CITY OF MERCER ISLAND

March 17, 2022

RE: Request for Information #2 for File No. SUB21-002 – Angiuli Pacific Res Trust Short Subdivision
4001 West Mercer Way, Mercer Island, WA 98040; King County Tax Parcel # 362350-0365

SHEET  
6 OF 9

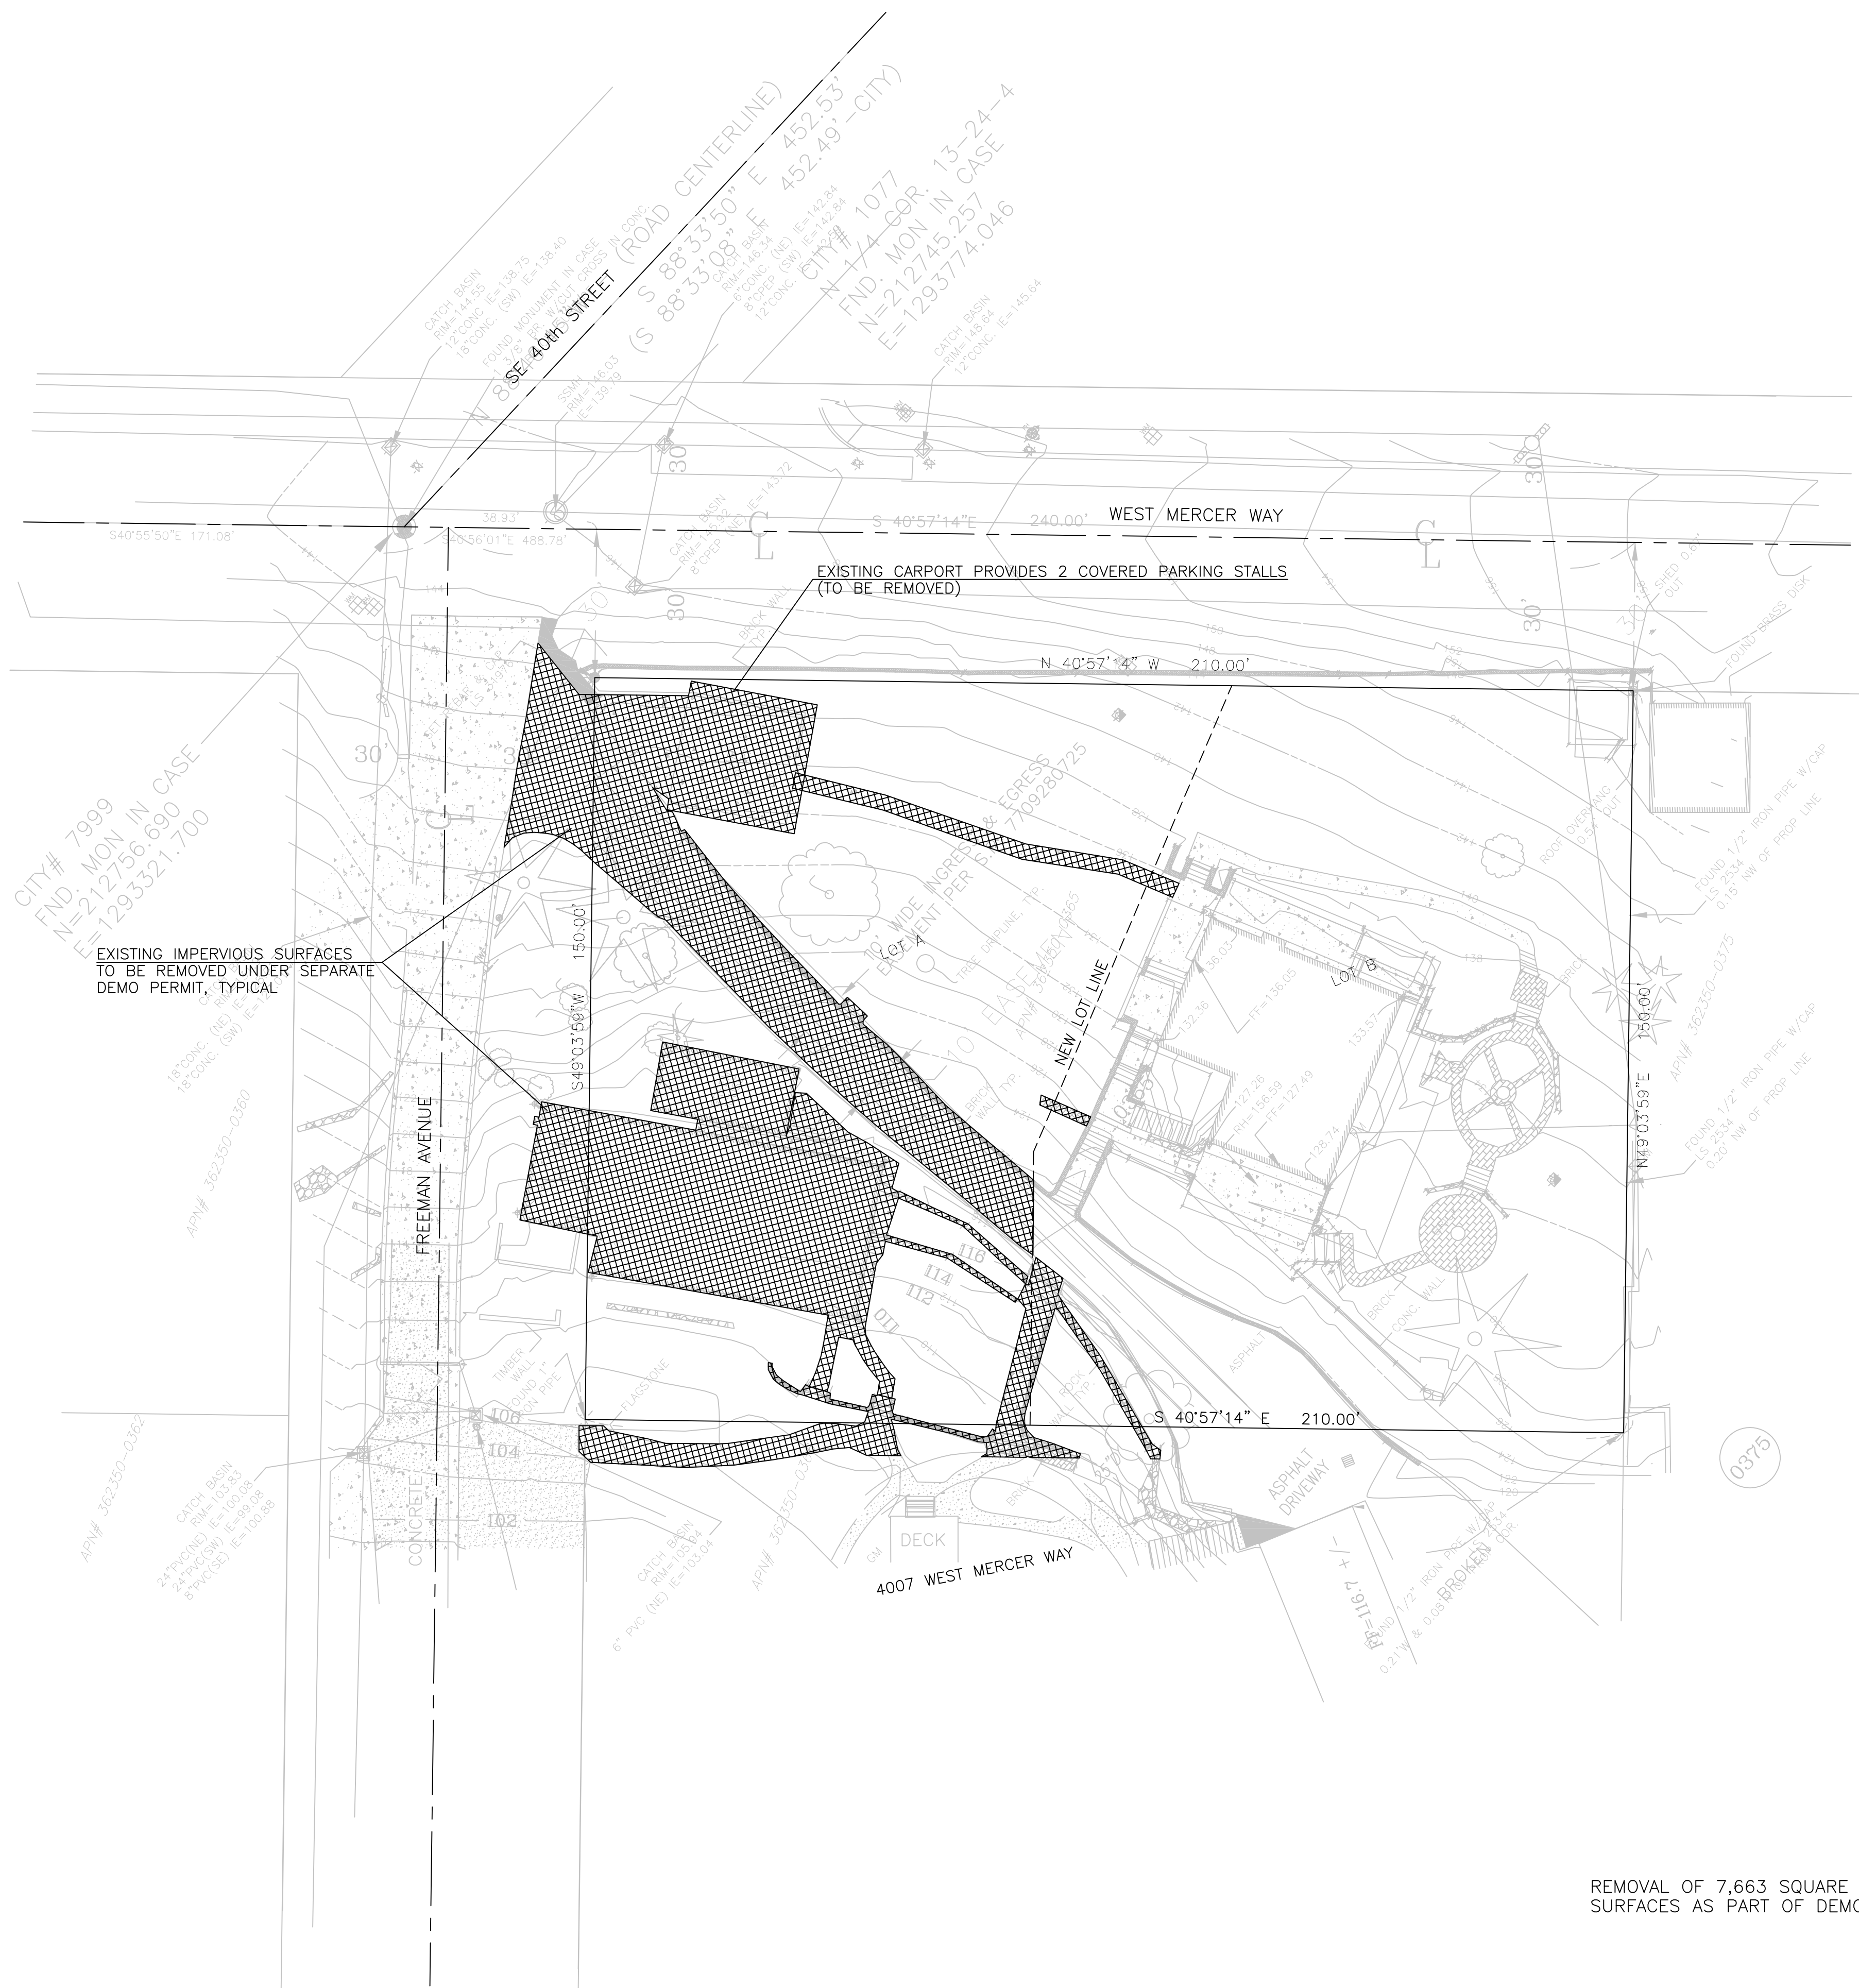
- a. In the applicant response letter, it was noted that the building pads were shown on sheet 6 of 9. Sheet 6 of 9, site plan, does not illustrate and label the two (2) building pad areas. Building pad area is different from proposed building footprint. Please refer to Attachment A Building Pad Examples.

- a. As requested by Fire, a portion of the proposed 20' access easement on 4007 West Mercer Way will be expanded which will impact net lot area. On sheet 6 of 9 please revise the net lot area for the "new 4007 West Mercer Way."
- b. Due to Lot A net lot area being close to the minimum 15,000sf at 15,002sf, a condition of preliminary plat approval will be that a note shall be added to the plat stating the following: "Lot A driveway placement shall be constructed as shown on sheet 6 of 9."
- c. Page 7 of 9: there is a note that states the following "existing impervious surfaces to be removed under separate demo permit, typical." The applicant has decided to apply for the demo permit after preliminary plat review. A condition of approval will be that the applicant shall update the lot coverage, hardscape, and impervious surface calculations for the final plat application.
